Jeffrey Peng
Department of Planning, Housing and Infrastructure
Major Projects Portal

State Environmental Planning Policy (Transport and Infrastructure) 2021
State Significant Development Application - SSD-63168959
269 Lane Cove Road, Macquarie Park
Request for additional information

9 September 2024

SECTION 2
SCALE: 1:200

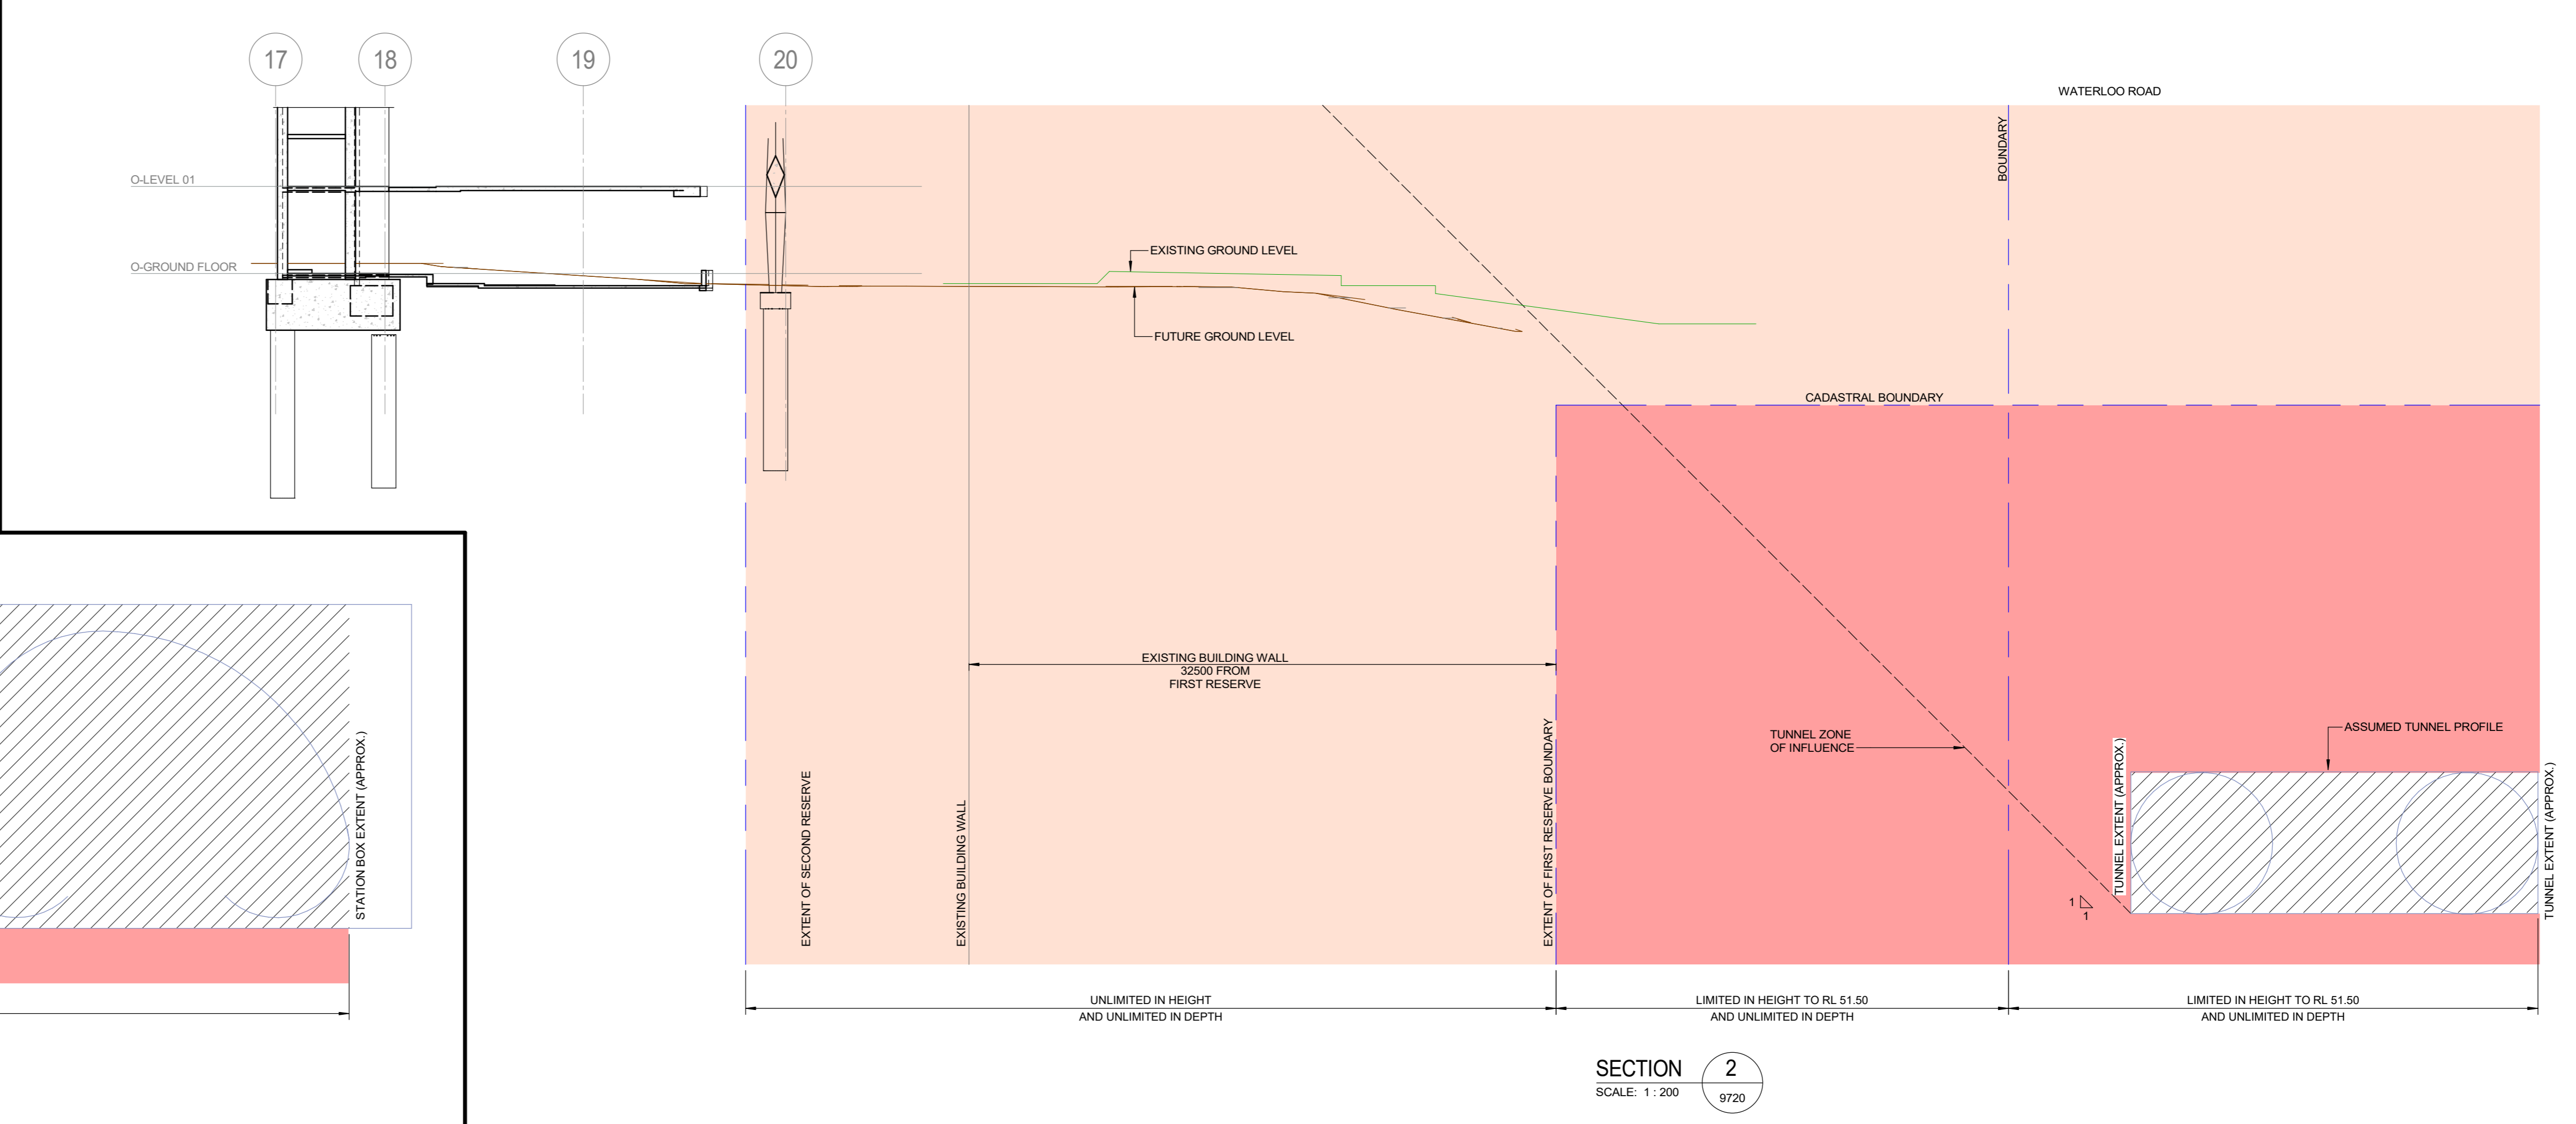
- a) A detailed survey plan showing the relationship of the proposed development with respect to the rail corridor and rail infrastructure.
- b) Cross sectional drawings showing ground surface, rail tracks, sub soil profile, proposed basement excavation and structural design of sub ground support adjacent to the rail corridor. All measurements must be verified by a registered surveyor.

- e) Structural design documentation for the development which demonstrates that:
 - i) the foundation design ensures that all loads from the development are transferred and have no adverse impacts on the rail corridor, rail infrastructure or rail easements;

- iii) any deformation induced by bulk excavation will not have adverse impacts on the rail corridor, rail infrastructure or rail easements.
- f) The construction methodology for the development, including details of the structural support to be provided to the development and rail corridor during excavation and operation of the development. The construction methodology must not propose any rock anchors/bolts (whether temporary or permanent) within Sydney Metro's land or easements during construction or operation of the development unless the Applicant has obtained prior written consent from Sydney Metro.
